Our Reference: SYD20/00773/10

Departments Reference: SSD-10479

**EXHIBITION OF EIS – AMMENDED PLANS & DOCUMENTATION – (106-228) 200
ALDINGTON ROAD INDUSTRIAL ESTATE - KEMPS CREEK**

Attachment A

**Figure 25: 2036 PM Peak Hour Traffic Distribution**

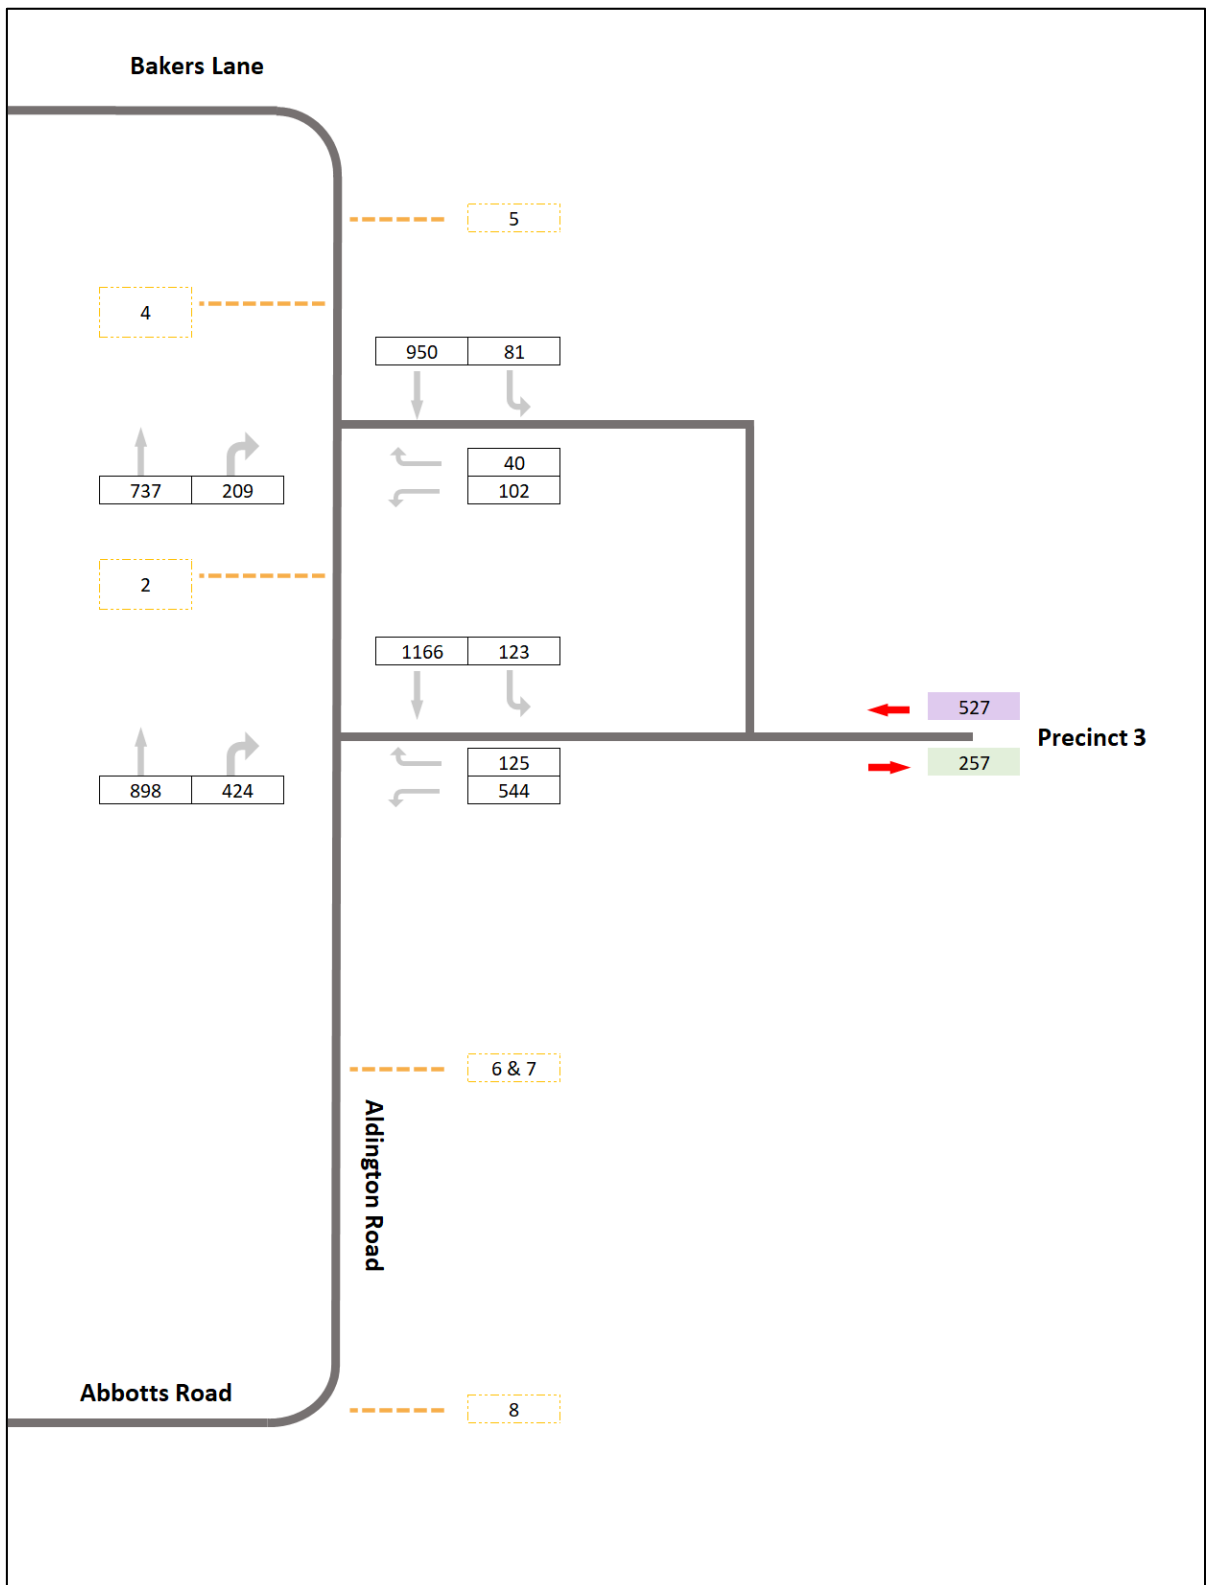
- d. A traffic assignment diagram should be provided showing what percentage of vehicle movements is proposed to travel north or south on Aldington Road. In addition further clarity is needed to ensure that the model provided directs all heavy vehicle movements to access Mamre Road from Abbots Road intersection and not Bakers Lane. This is due to the presence of schools along Bakers Lane.
